WINDERMERE

PRELIMINARY PLAN

EL PASO COUNTY, COLORADO

PRELIMINARY PLAN

# PP08

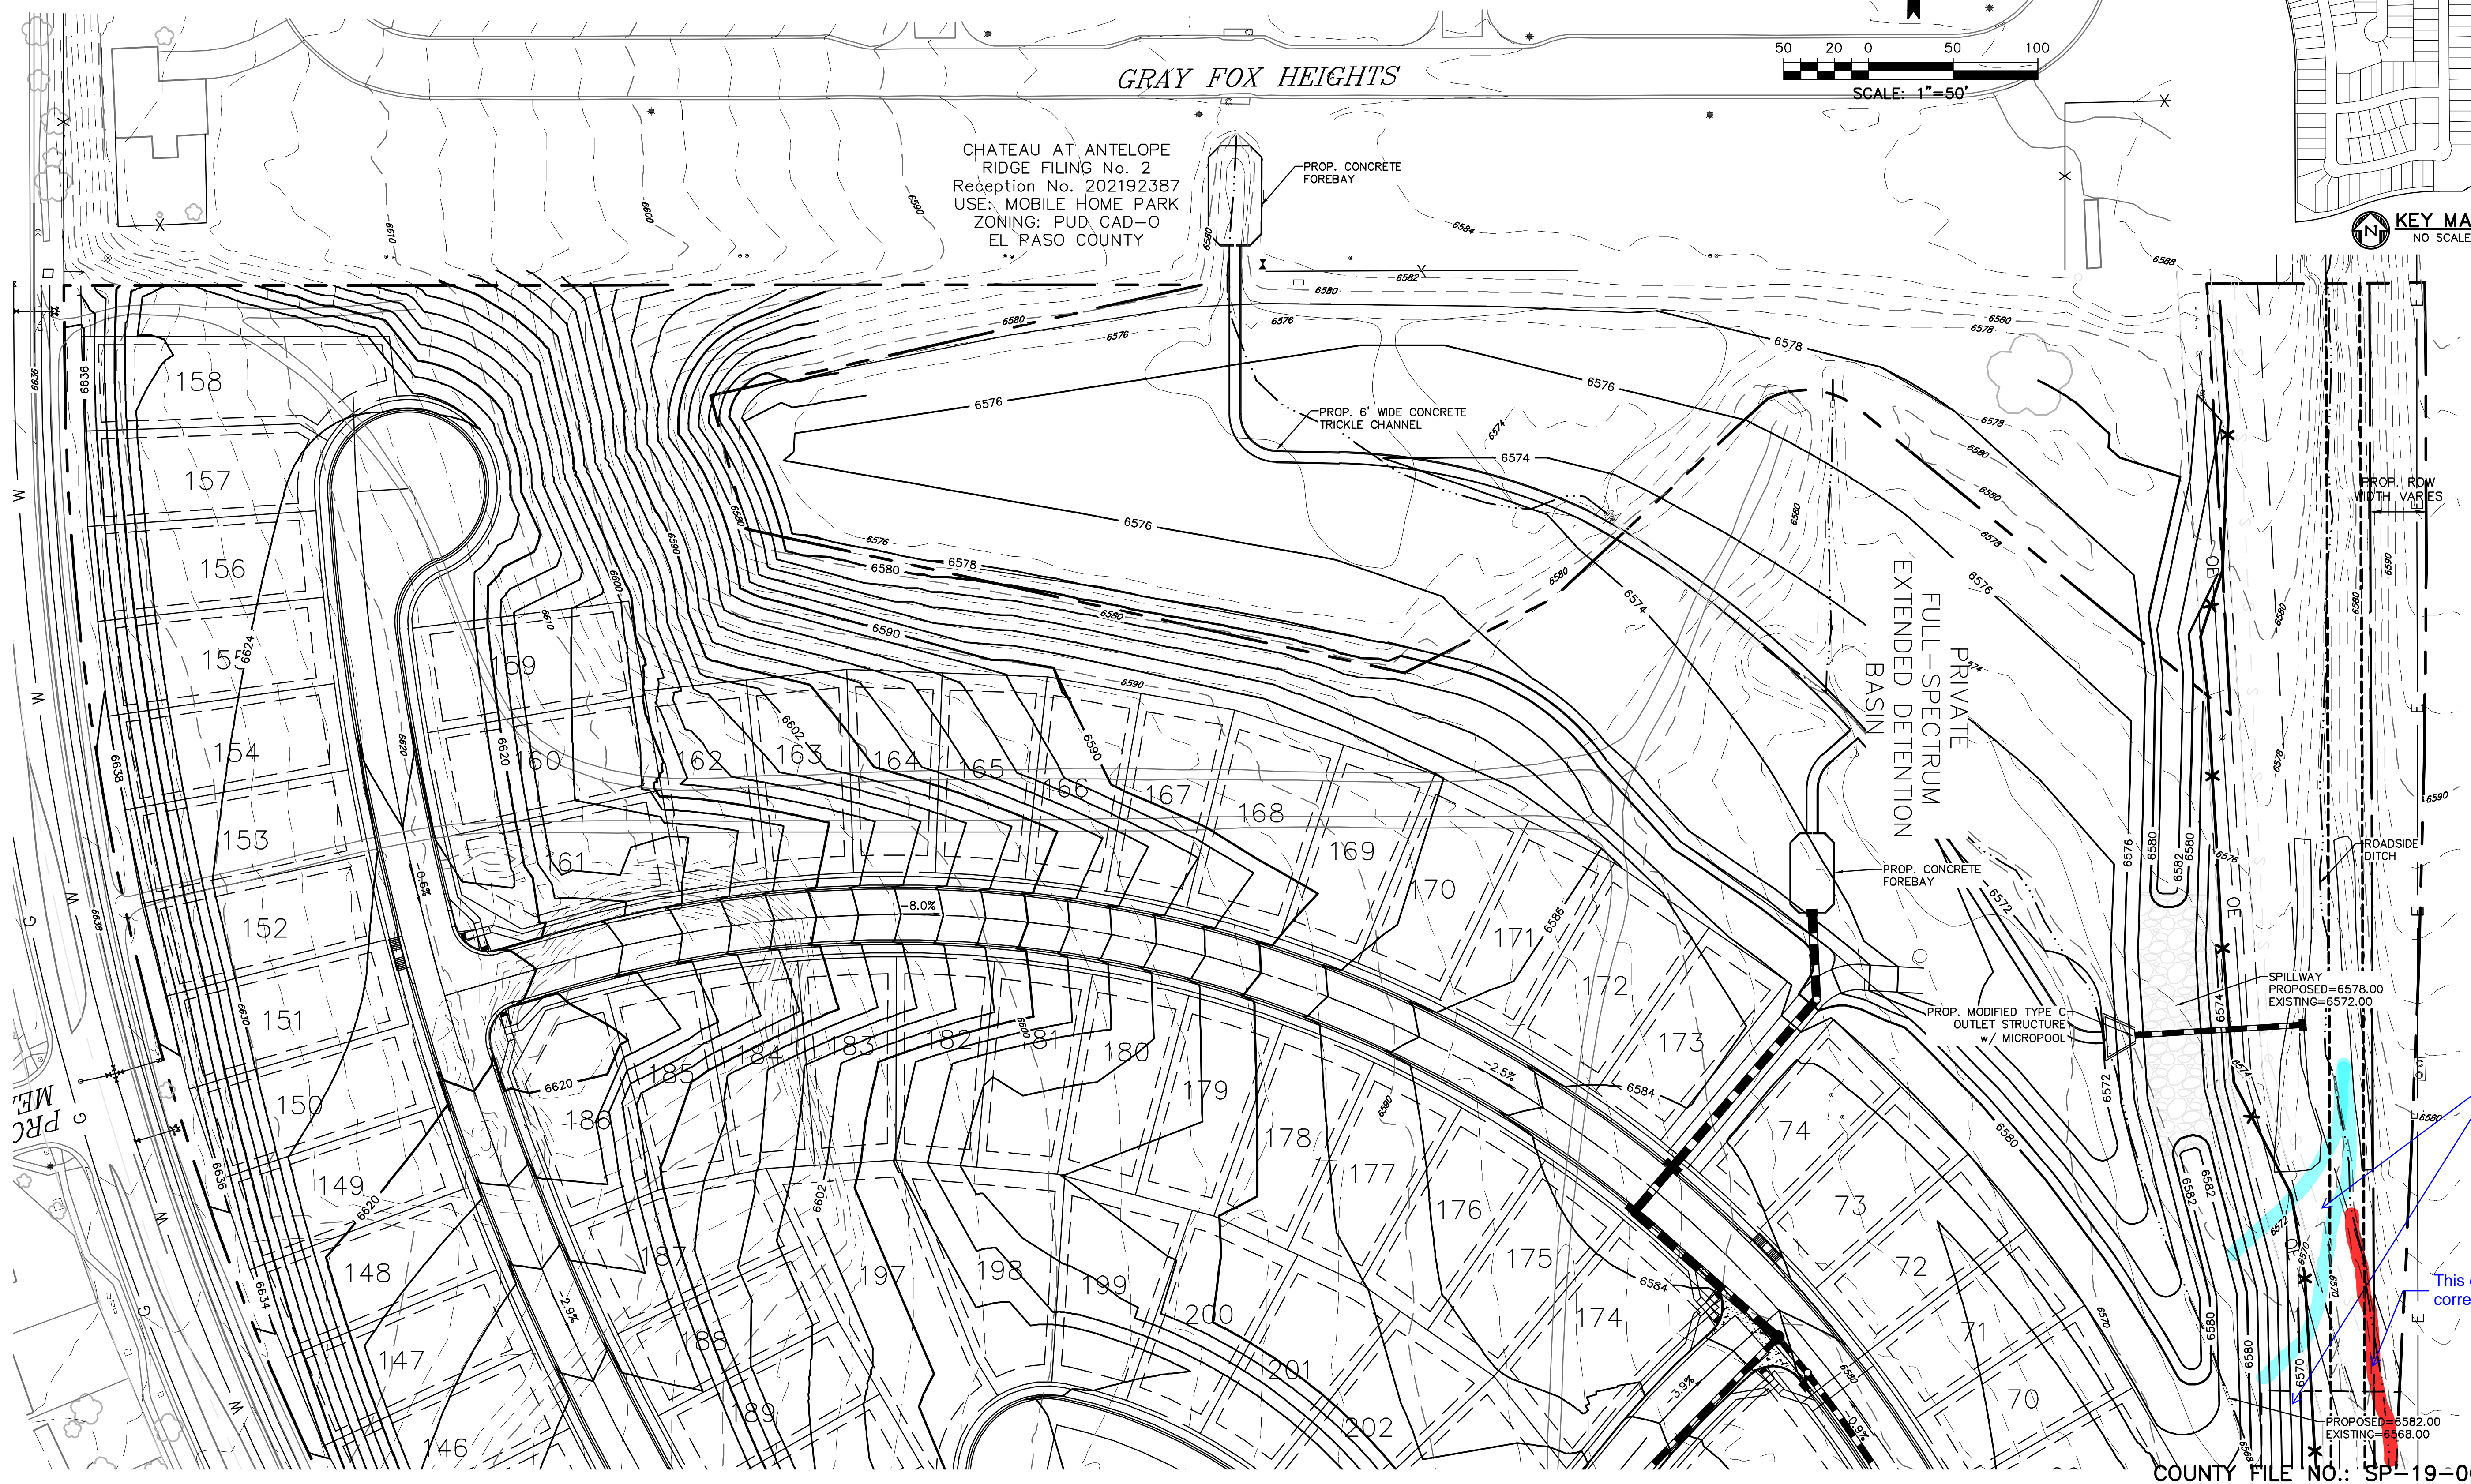
Should these rear lots be elevated to avoid future culvert backwater?

Label existing and future culvert type and size

Label all drainage facilities.
